Epping to Thornleigh Third Track Proposal. Application number SSI 5132.

I/we object to the Epping to Thornleigh Third Track Proposal and consider that the EIS is inadequate and does not address the full impact of this proposal. It will cause untold damage to the health of residents and to the fabric of the Beecroft Cheltenham Heritage Conservation Area. Do not approve this project, reconsider the alternatives and protect the community.

Figure 5.6 Cross-section and elevation - New Cheltenham Station concourse building
Note: Indicatively added to future design

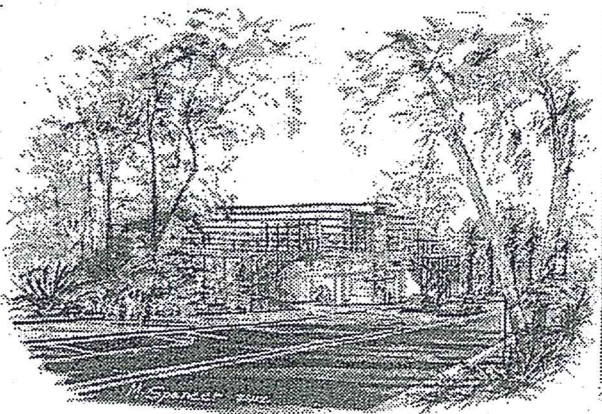
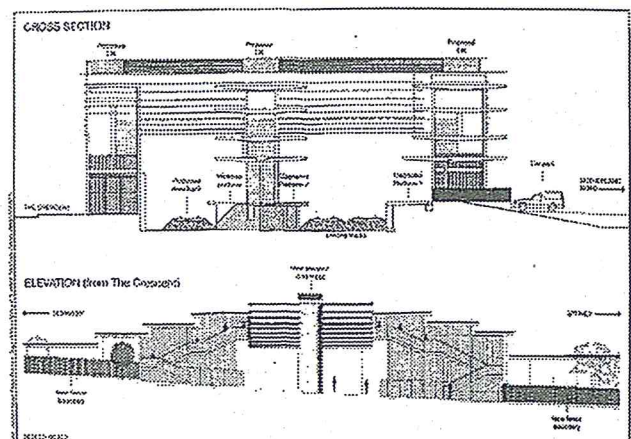
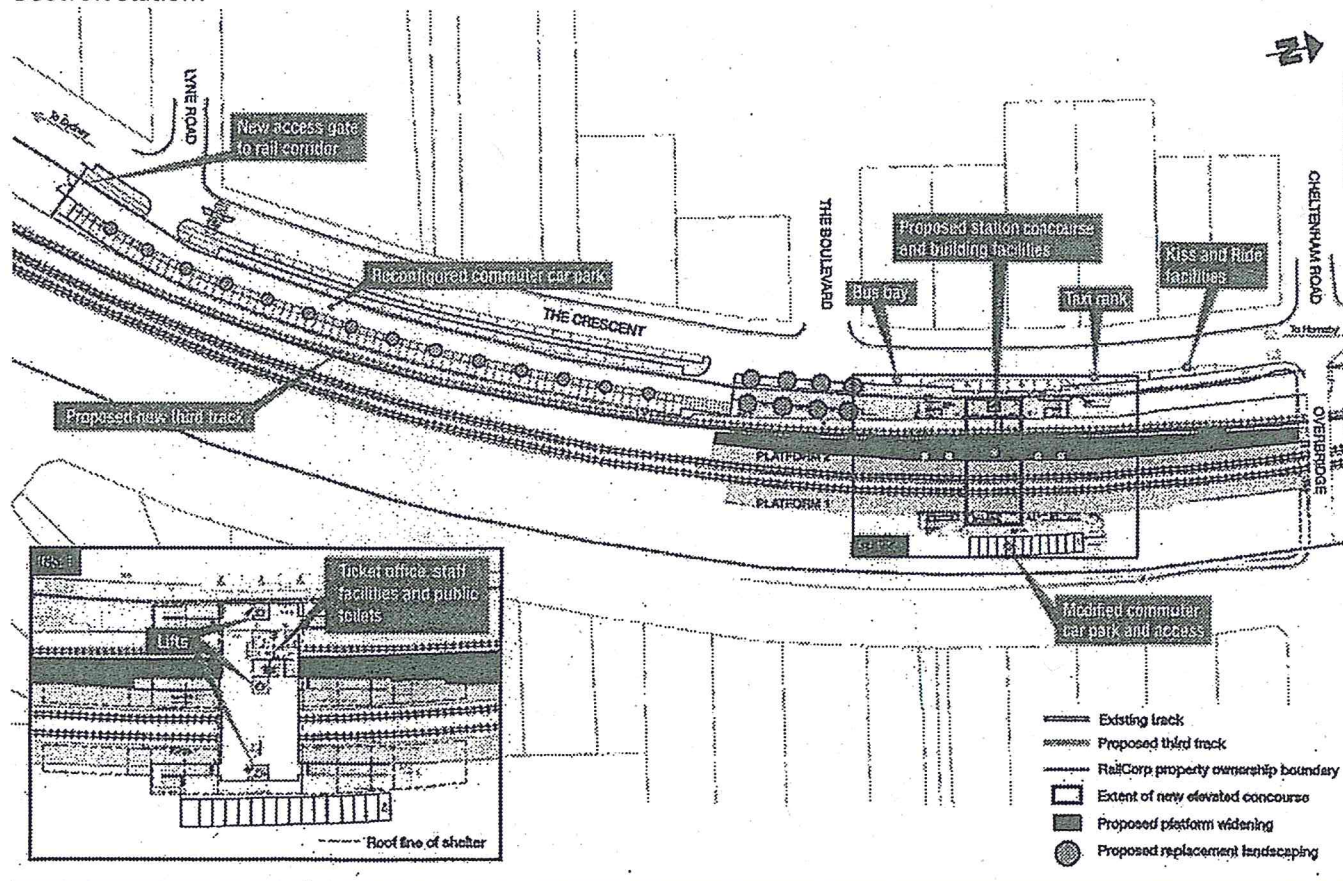
- The proposed redevelopment of Cheltenham Station shows no regard for the HCA. The visual impact of the proposed 13m high glass and steel concourse is totally unacceptable in this HCA.

Concept design drawing of proposed changes to Beecroft Station (Parsons Brinckerhoff 9/3/12). Former side platform shaded in pink.

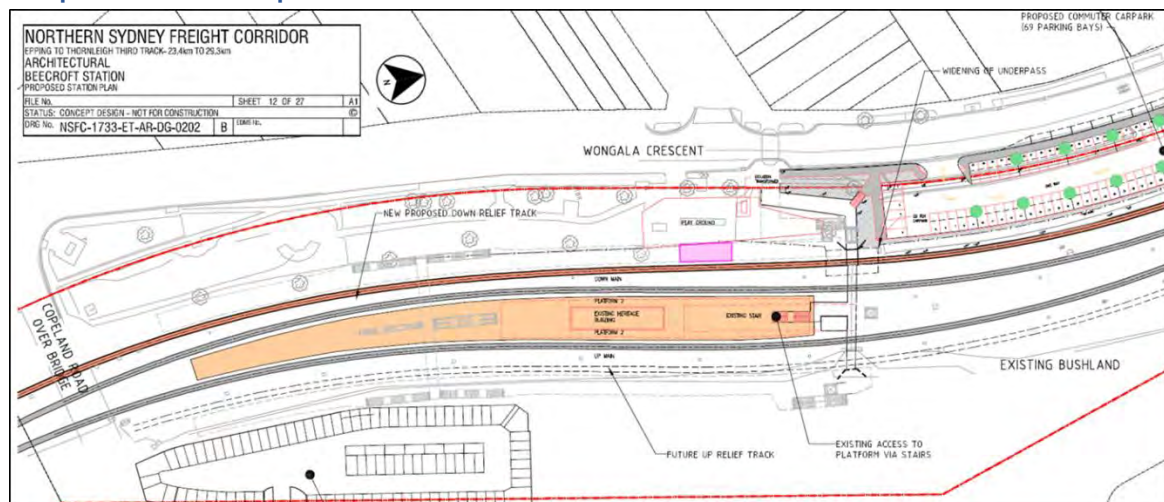
- There has been inadequate assessment of the project's impact on the fabric of the Beecroft Cheltenham Heritage Conservation Area (HCA).
- The plan given for Beecroft Railway station Precinct is vague. The relationship to the trees, playground and original 1895 platform located south of the present station is not shown. A fourth track is shown on the eastern side. The plan does not include urgently needed lifts to allow disabled access at Beecroft Station.

- Beecroft Station Gardens have a heritage listing with Hornsby Council but the impact on them has not been adequately addressed. No arborist's report is given for the trees which will be removed.
